From: [Megaw, Alice](#)
To: [DraxBECCS](#)
Subject: EN010120 Drax BECCS Natural England relevant representations
Date: 23 September 2022 11:24:55
Attachments: [image001.png](#)
[402545 Drax-BECCS-EN010120-Natural England Relevant Reps Version 1.2.pdf](#)

NSIP Reference Name / Code: EN010120

Title: Natural England's comments in respect of Drax Bioenergy with Carbon Capture and Storage Project, promoted by Drax Power Limited

Natural England's Relevant Representations Version 1.2.

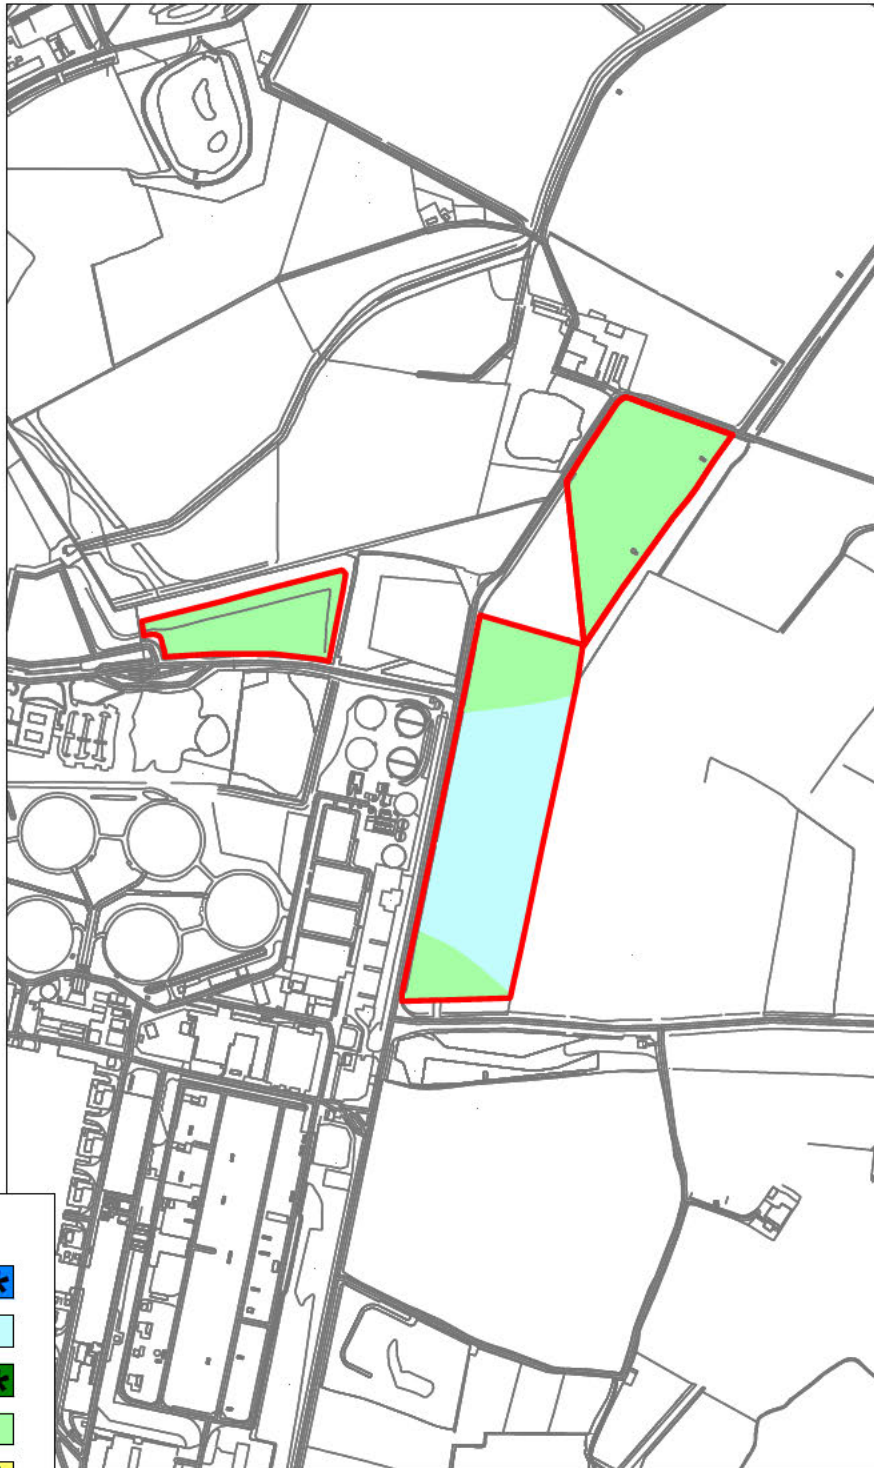
2.5.1. Natural England provided discretionary advice to WSP (on behalf of Drax Power Limited) on 5 May 2022 regarding the Agricultural Land Classification (ALC) Methodology Approach for the Drax BECCS DCO Application. Comment was also provided regarding the agricultural land and soils environmental impact assessment (EIA) methodology. It appears that the ALC report and EIA have not been updated in response to the discretionary advice (DAS) provided in May 2022, other than the provision of an ALC plan of the site (Figure 11.2).

2.5.2.1. The ALC Grade should be calculated for all agricultural land (or land which was last used for agricultural use) subject to proposed development or disturbance ('amber').

<p>management and sustainable re-use, as at present it remains un-surveyed.</p> <p>Two areas of land subject to the ALC survey (eastern parcel and central parcel) have not been assigned an ALC Grade based on their current non-agricultural land use. The ALC Grade is not based on the current land use or cropping of the land, but the inherent capability of the land.</p> <p>The ALC Grade should also be calculated for the western parcel with the data presented in Appendix 11.2.</p> <p>Further detail can be found in the Guide to assessing development proposals on agricultural land - GOV.UK (www.gov.uk).</p>		
16	Soils and Best and Most Versatile Agricultural Land	<p>Additional information should be provided in the Environmental Statement Chapter 11 Ground Conditions – EIA Methodology</p> <p>(C)</p>	<p>The Environmental Statement Chapter 11 Ground Conditions – EIA Methodology (6.1.11) should include a detailed breakdown of the land take into permanent and temporary losses for the different types of land use within the proposed development, broken down by ALC by area (ha) and percentage.</p> <p>The EIA should acknowledge the potential impact to the agricultural land beyond the East Construction Laydown Area.</p> <p>The Environmental Statement Chapter 11 Ground Conditions – EIA Methodology (6.1.11) criteria presents a modified EIA</p>	<p>The EIA should be in line with the methodology presented in the ICE (2019) EIA handbook. Consideration of the development impacts on the soil resource and soil function should also be considered (IEMA guidelines (2022)).</p> <p>The Environmental Statement should include a detailed breakdown of the land take into permanent and temporary losses for the different types of land use within the proposed development, broken down by ALC by area (ha) and percentage.</p> <p>Natural England advises that the outcomes of this assessment should inform any</p>	Amber
